Planning Inspectorate

Reference: OR-0010831/01

Deadline 3 submissions - EA 04 follow up response

The Drovers Solar Farm

Drawing file: published-documents / EN0110013-000634-6.3.1 ES Figure 12.10 Groundwater Flow Directions from NEAC Groundwater Model.pdf

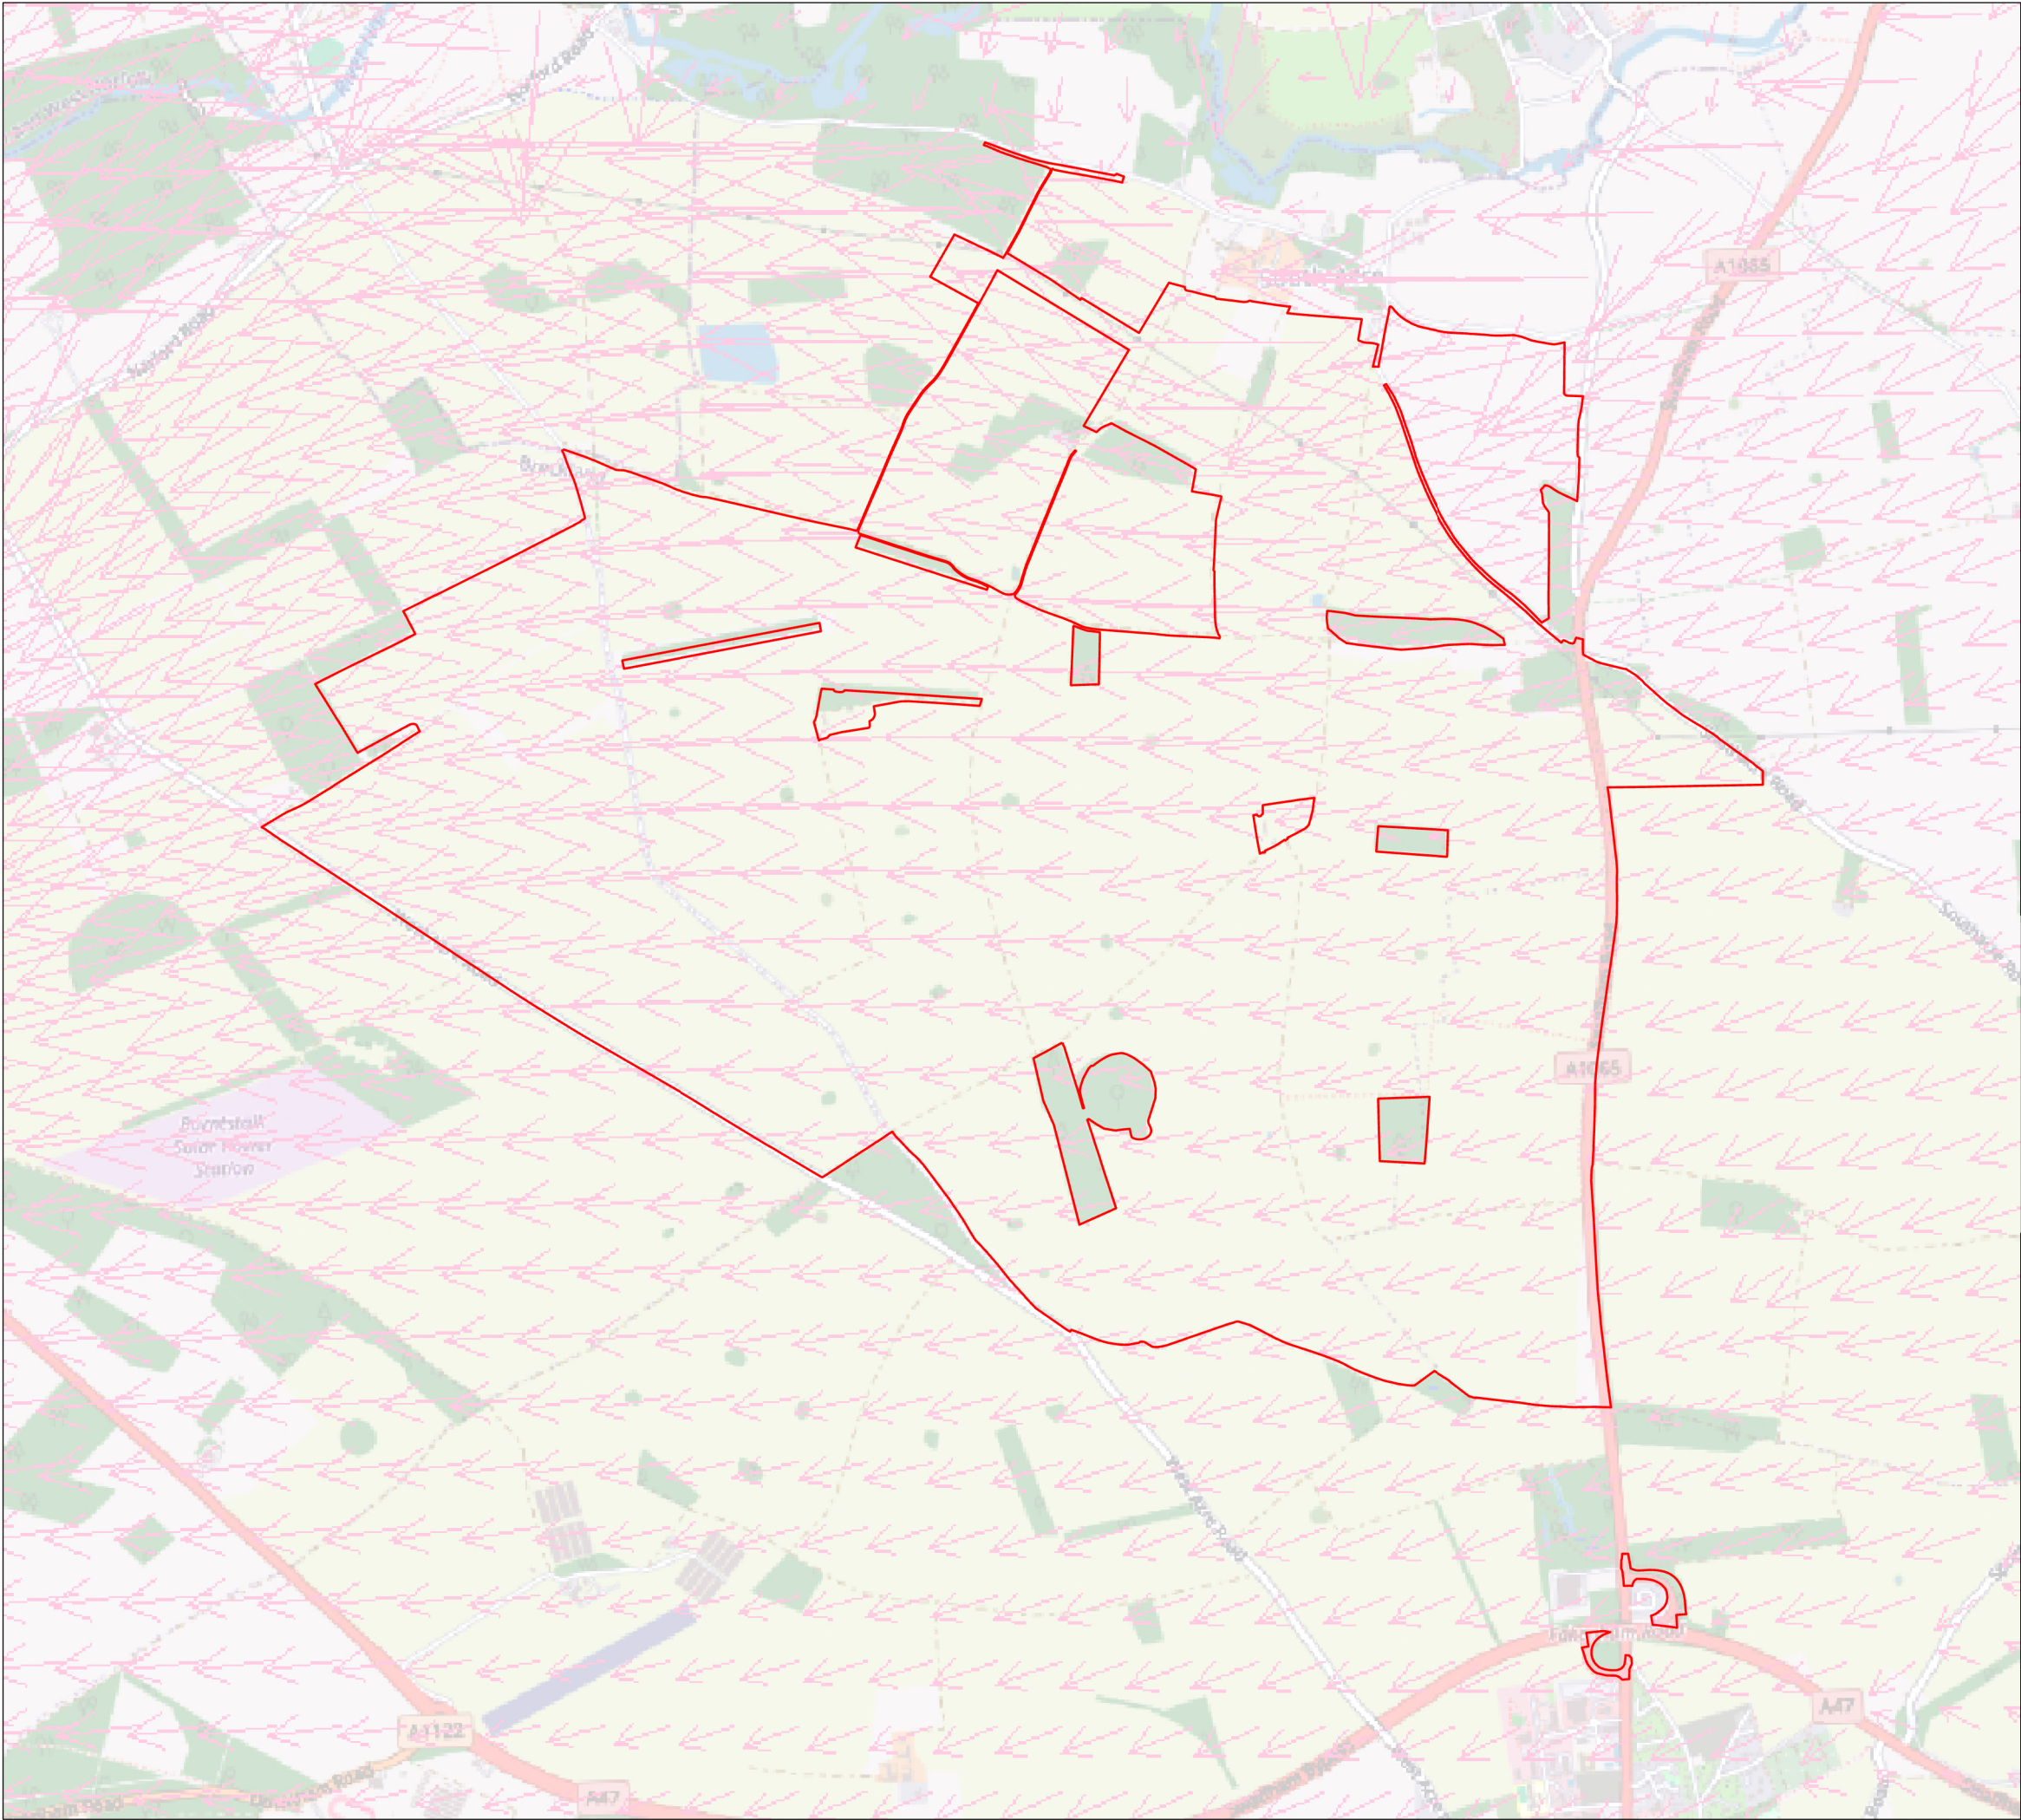
We were concerned that the groundwater flow direction shown in figures 12.7 to 12.16 may be inaccurate. We advised that the claims made in sections 12.6.37 and 12.6.38 of 6.2 Environmental Statement Chapter 12: Water Resources [APP-061] should be revised, supported by new evidence.

The North-East Anglian Chalk (NEAC) Groundwater Model outputs are an improvement on those derived from interpolating between borehole levels measurements supplied previously. The 6.3.1 ES Figure 12.10 Groundwater Flow Directions from NEAC Groundwater Model [\[REP3-041\]](#) shows general horizontal groundwater flow across the site. This will give the Applicant a better conceptualisation to assess flow pathways for potentially polluting substances used in construction/operation, and the potential impacts sub-surface works may have to the local hydrogeological regime. Therefore, we are content to resolve this issue.

The map shown within Figure 12.10 does appear to be the dry weather scenario output for the Chalk top layer (layer 5 of the model), rather than the wet Scenario

referenced in 12.6.44 of 6.2.2 ES Chapter 12 Water Resources (Tracked) [\[REP3-037\]](#).

The new figure 12.10 does show the correct direction, even though it is incorrectly labelled. Considering the Applicant is committed to groundwater monitoring in the 7.6.3 outline Construction Environmental Management Plan (Tracked) [\[REP3-074\]](#), (table 6) this should be sufficient to mitigate risks to groundwater, now that the conceptualisation of groundwater is generally correct.

- To either change the references to Figure 12.10 to the correct scenario (ie. Wet to Dry) or add the correct figure if available;
- Change reference to the groundwater model used to create the bespoke NEAC groundwater model (ie. TUFLOW 5 to MODFLOW 5)
- Correct the source for data used in Figure 12.9.
